**Native Sun Construction Preliminary/Final PUD Plan and Filing No. 1 – Final Plat
Response to Review Comments
December 2021**

NATIVE SUN CONSTRUCTION
PRELIMINARY/FINAL PLANNED UNIT DEVELOPMENT
LANDSCAPE PLAN

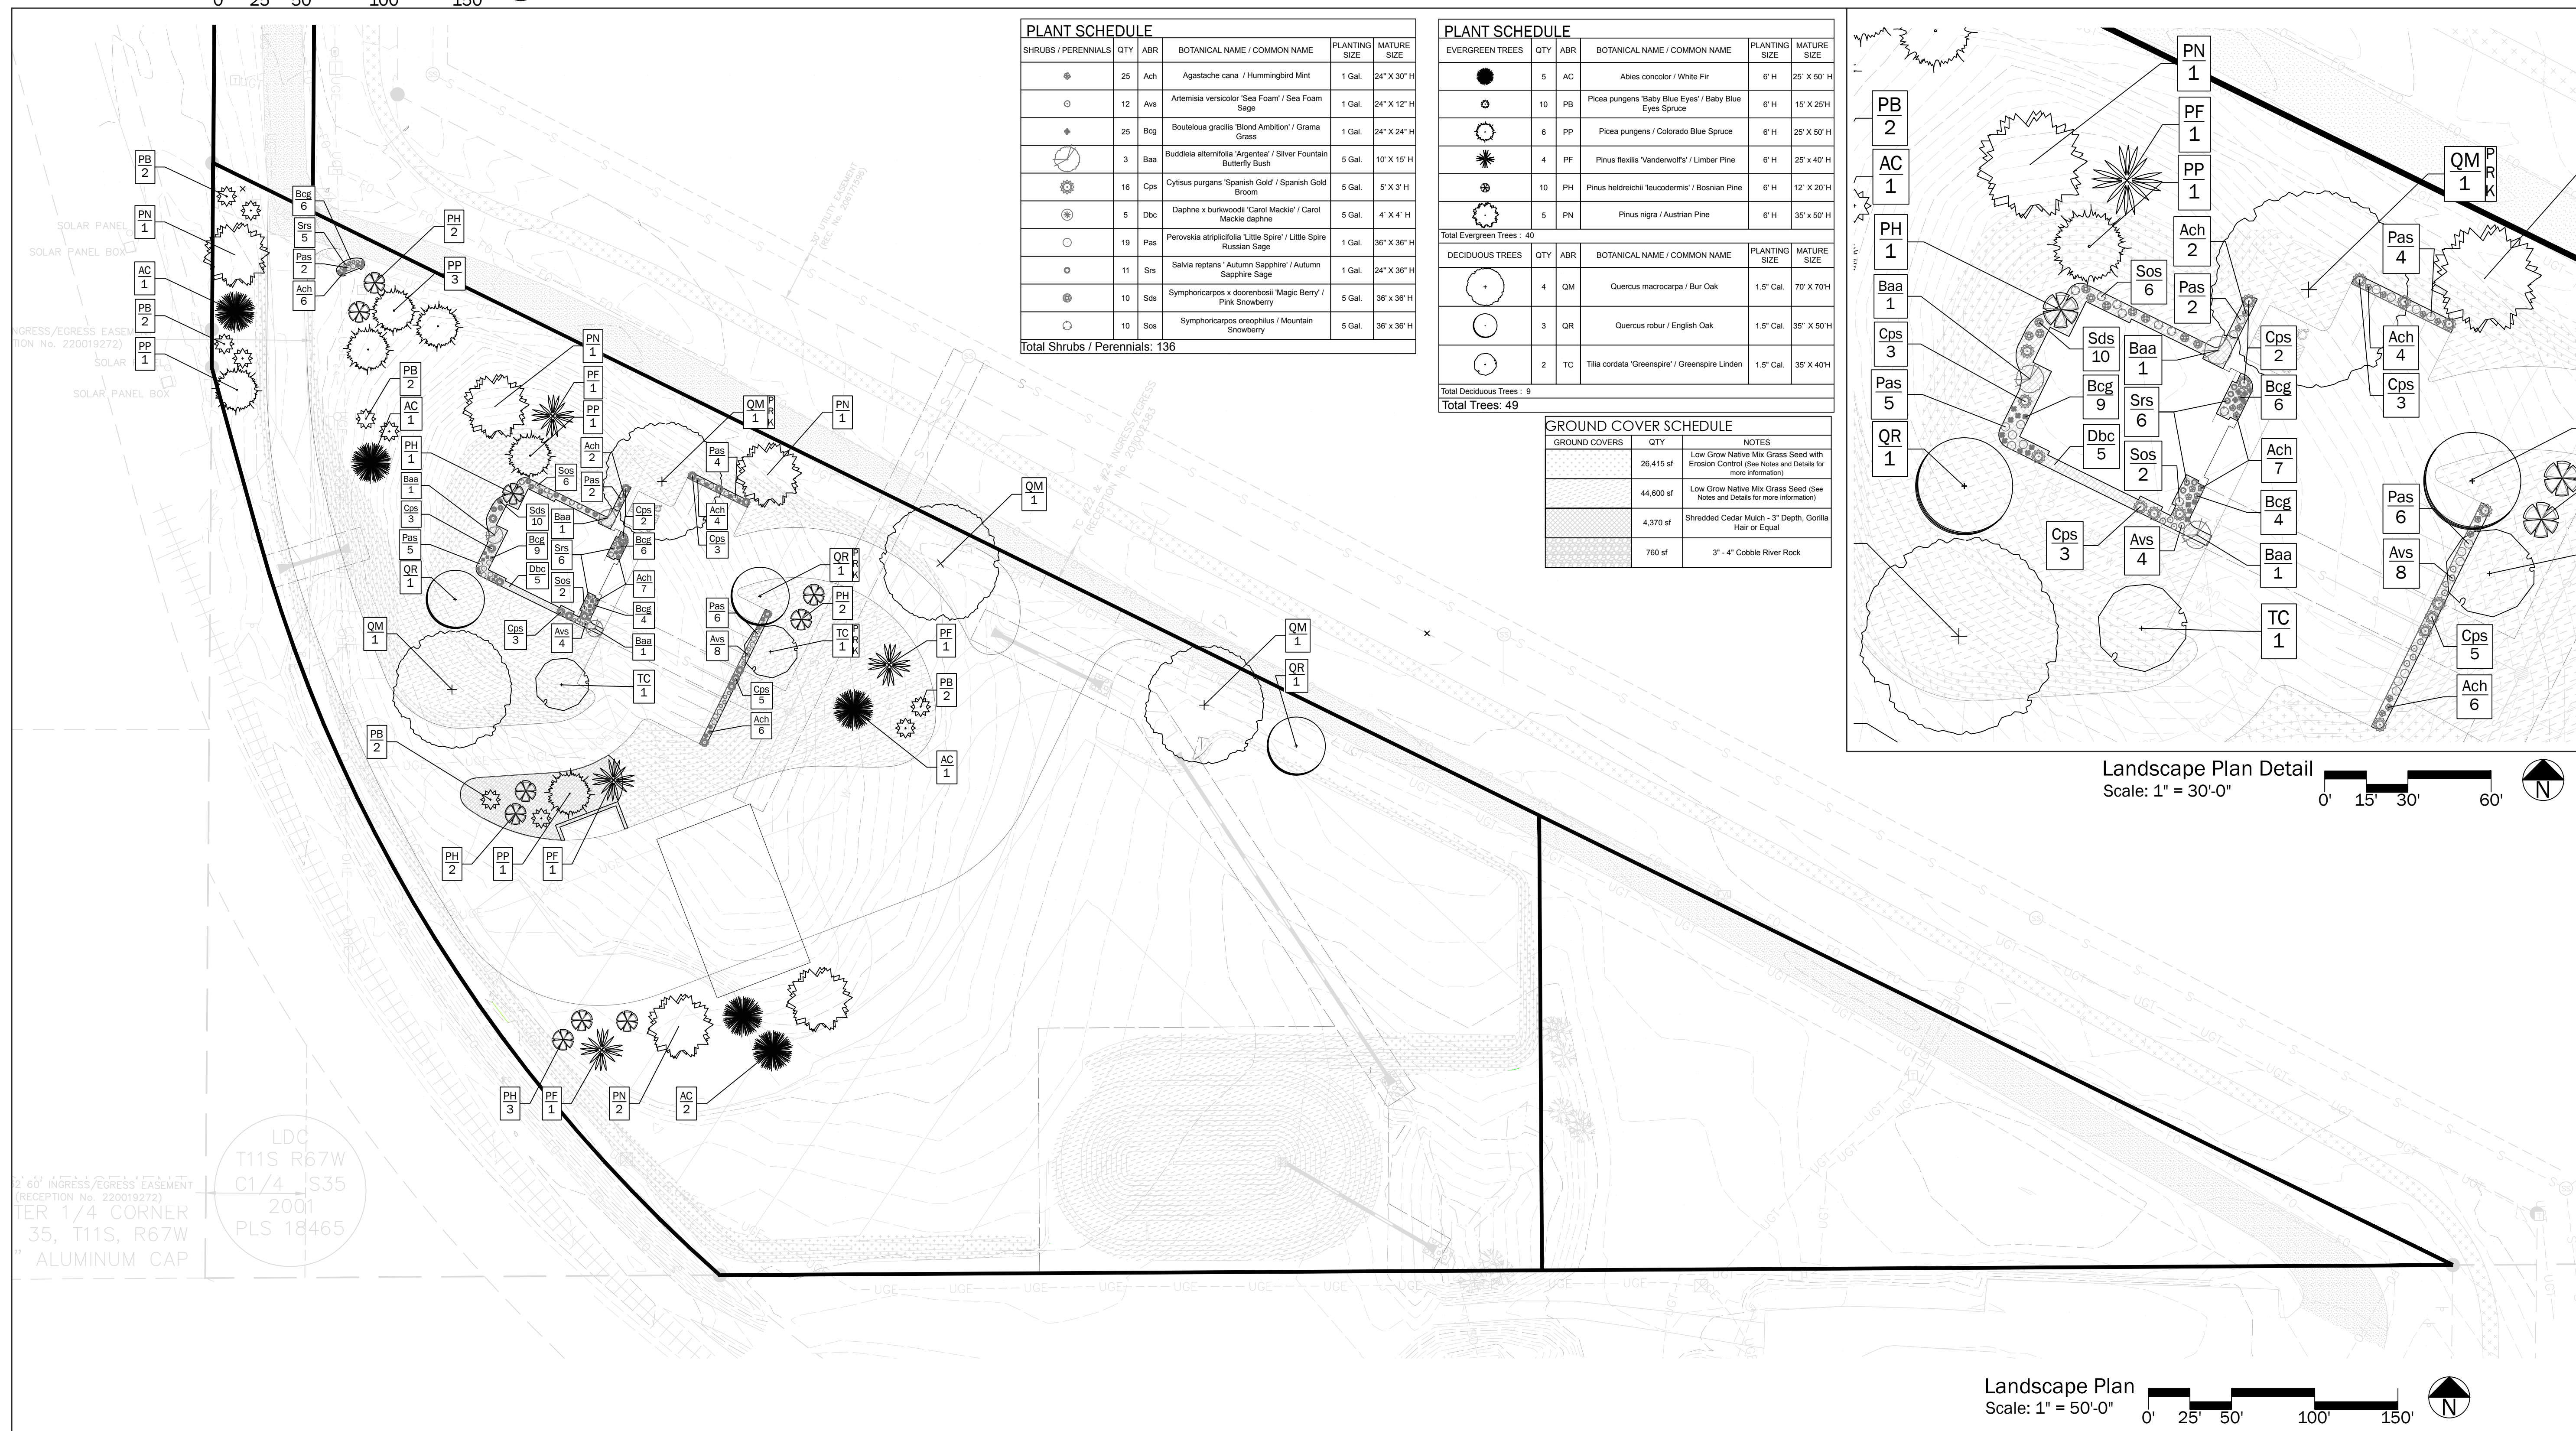
19. Verify shrubs/perennials proposed on the plant schedule are on the Monument Landscape Guidelines per Town code 18.05.450 (A1).	With the exception of <i>Perovskia atriplicifolia</i> 'Little Spire' and <i>Salvia reptans</i> 'Autumn Sapphire', all proposed shrubs and perennial are specifically listed in the Monument Landscape Guidelines. Little Spire, formerly classified within the <i>Salvia</i> genus, is extremely closely related to multiple sage species approved by the Town of Monument. Further the species is known to be an extremely hardy, water-wise species consistent with the objectives of the Landscape Guidelines. Similarly, Autumn Sapphire is sub-species of one of the approved plant species list within the Landscape Guidelines and has been identified as a Colorado Plant Select species that meets Monument's goals for landscaping. Due to their close relation/sub-species classification to approved perennials, these two plants will be excellent additions to the project.

20. Planter beds within the parking lot area should be a minimum of 9' wide per Town code 18.05.245 (12D).	Planter beds within the parking lot area have been updated to a 9' depth.

Irrigation Plan
Scale: 1" = 50'-0"

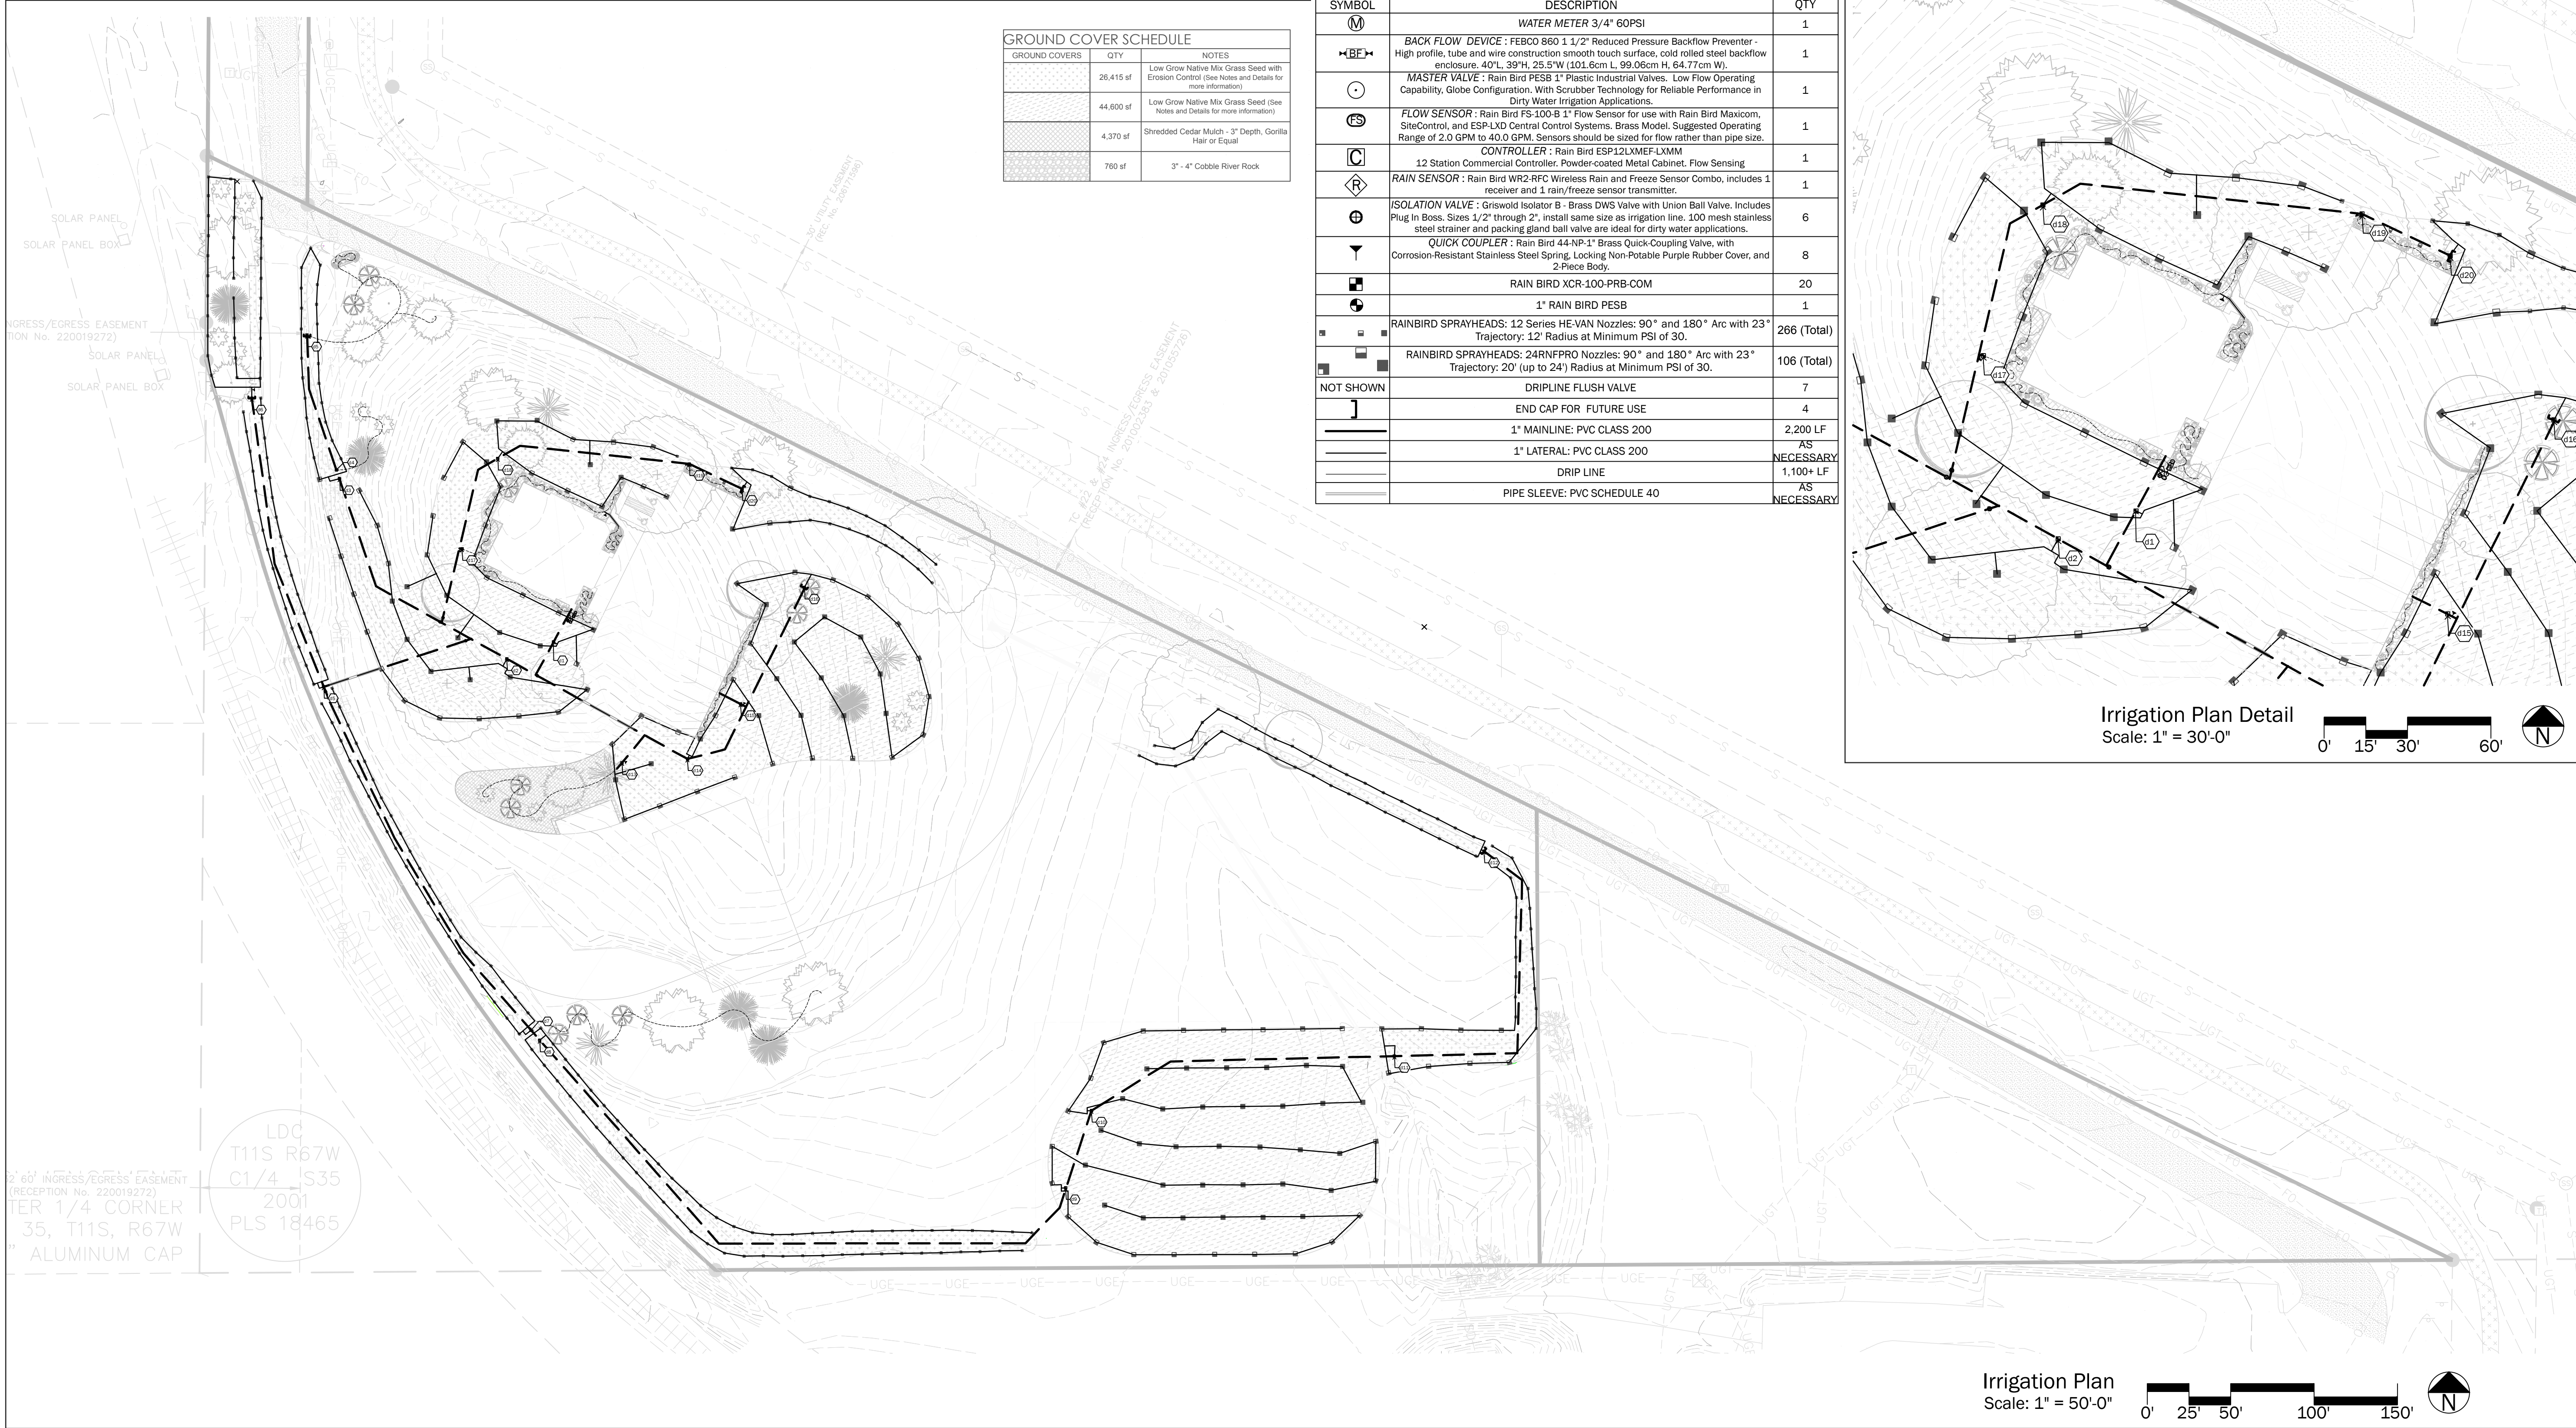
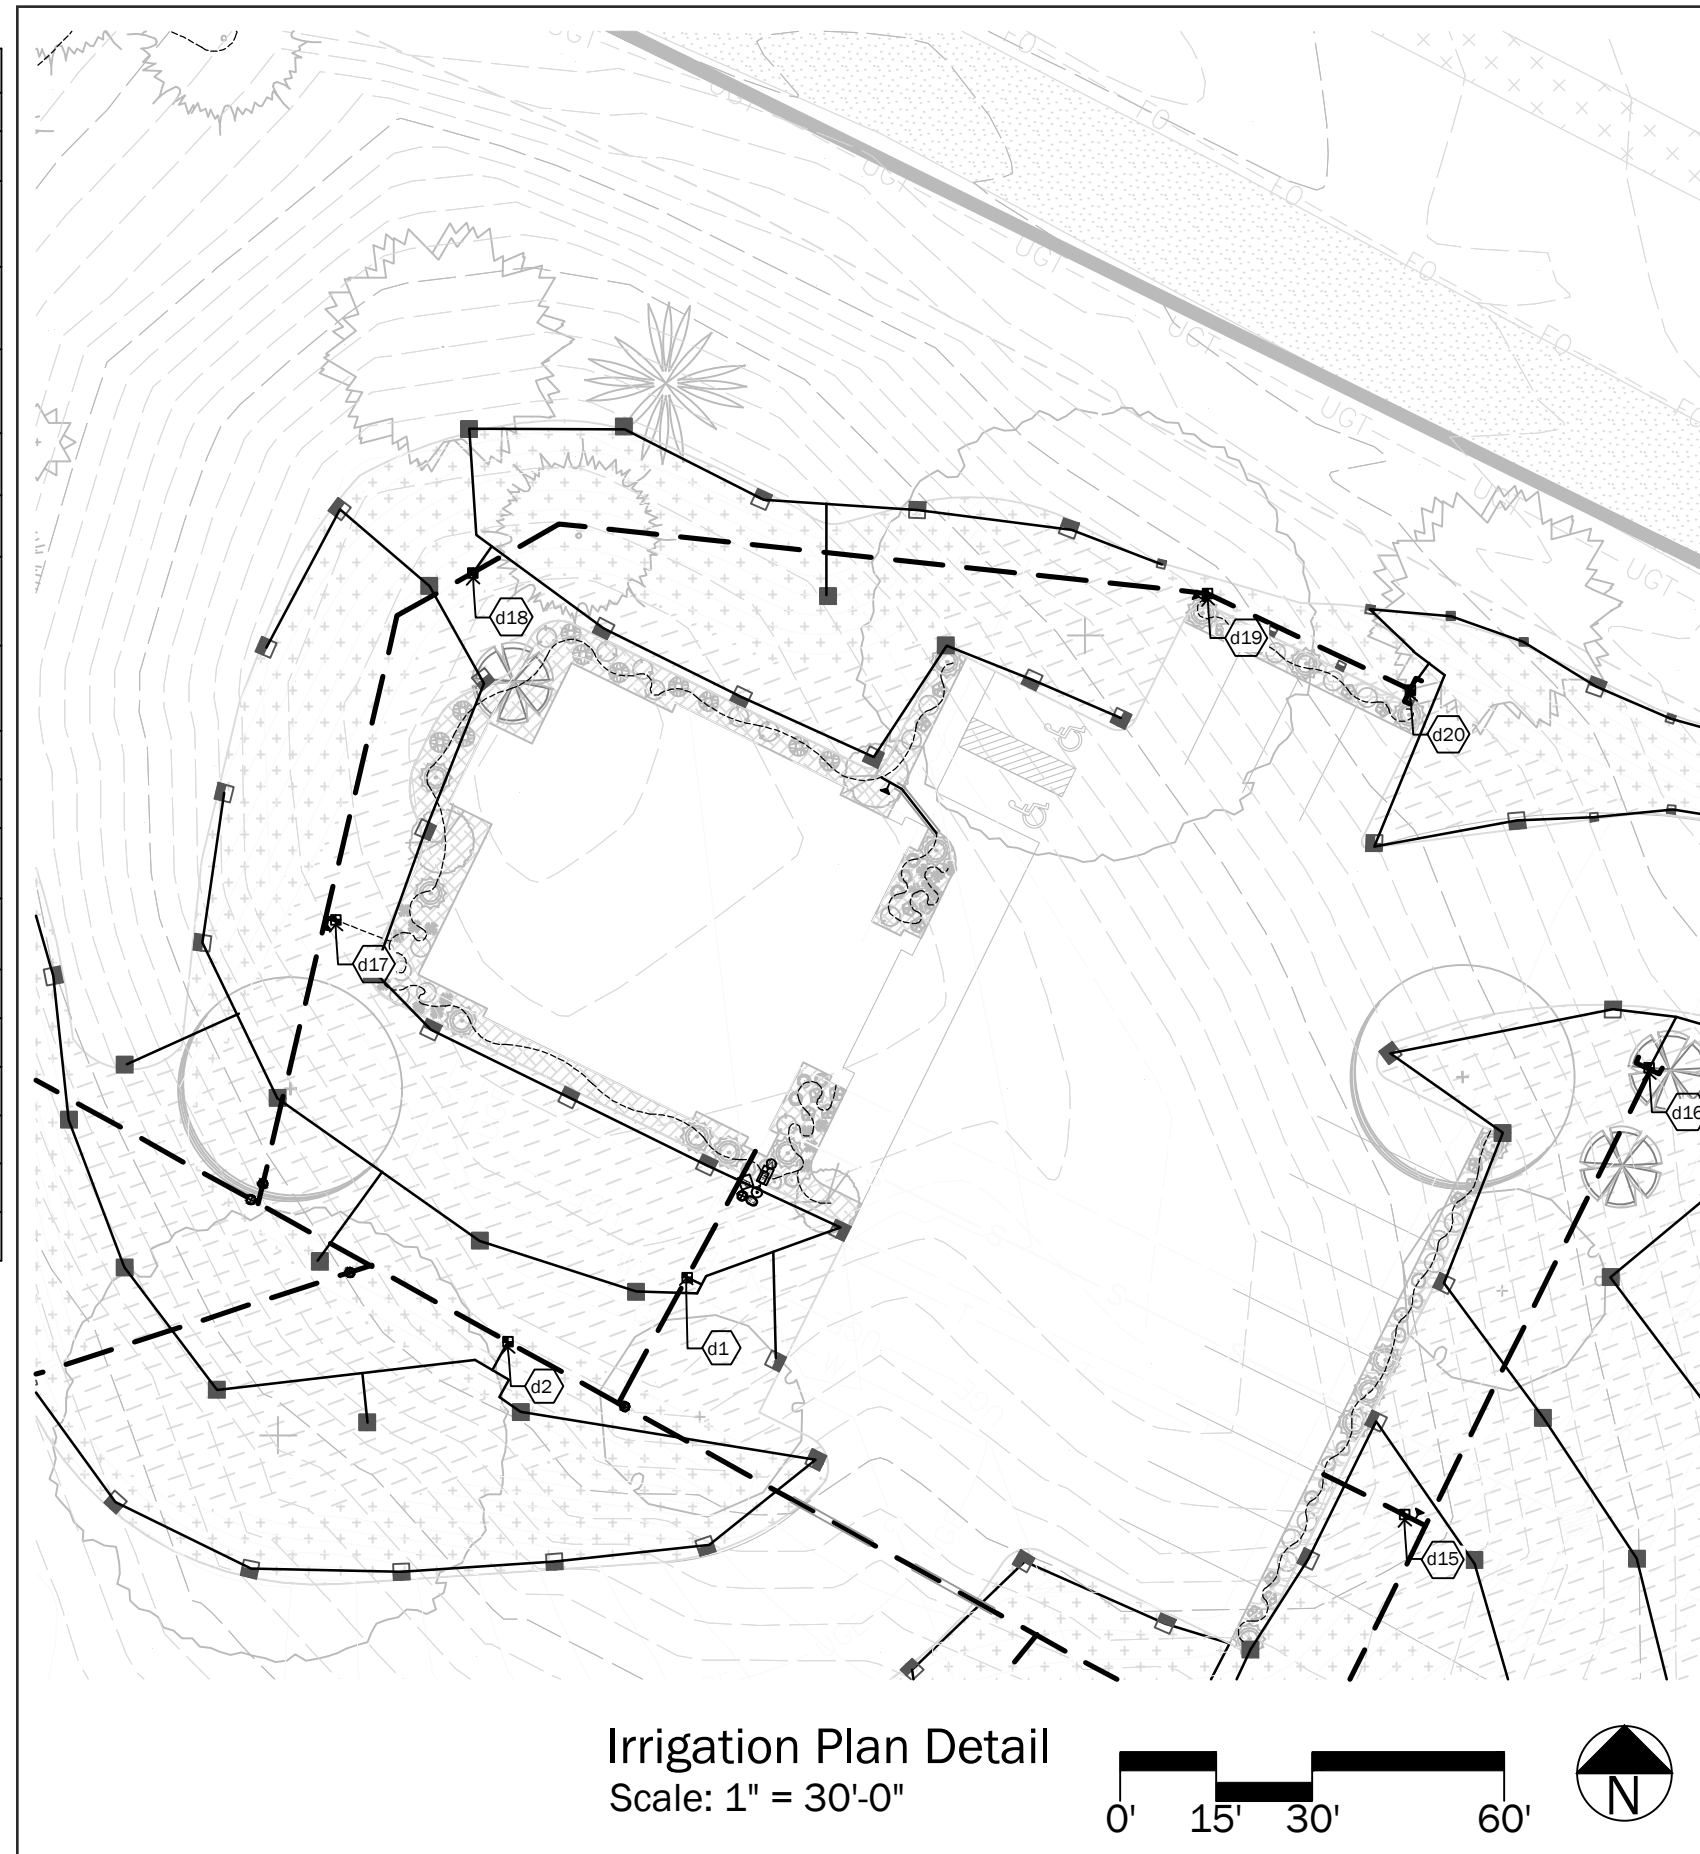
22. The irrigation schedule doesn't match up with the plan. For example, s3 is supposed to be d3?	The irrigation schedule and plan have been updated to correct this concern. The zone key includes spray valves listed numerically with drip valves being further identified with a 'd' and a numerical designation.

23. Mainline and dripline is shown as dashed on the plan, but solid on the irrigation schedule.	The plan has been updated to correct this concern.
24. Show point of connection and other irrigation appurtenances on plan as shown in the irrigation schedule.	A clearly identified point of connection is now shown on the plans. For further detail, please see the enlarged inset plan showing the connection near the Native Sun Construction office building.

25. Verify flow rates for each valve. For example, a few spot checks show the flow rates described in the valve schedule to be too low for the amount of proposed pop-ups specified on a single valve.	Additional valves and zones have been added to ensure sufficient flow rates for the project's irrigation and to address this comment. Final flow rates will be provided once the GMP flow rate at the point of connect is identified.
Scot Hail, Business Developer - Comcast Business	No response required.
<i>Scot_hail@comcast.com</i>	
No comments submitted at this time.	
Rickey Nelson, Advanced Communities Manager – Comcast Communities	No response required.
<i>Rickey_nelson@comcast.com</i>	
No comments submitted at this time.	
Jamey Bumgarner, Fire Marshal - Tri-Lakes Monument Fire Protection District	No response required.
719-484-0911, <i>jbumgarner@tlmfire.org</i>	
Tri-Lakes Monument Fire Protection District has reviewed the Native Sun Construction Preliminary/Final PUD Plan. Based upon our review of the proposed development for fire apparatus access, emergency egress, and FD water supply, we find the project acceptable per the following conditions:
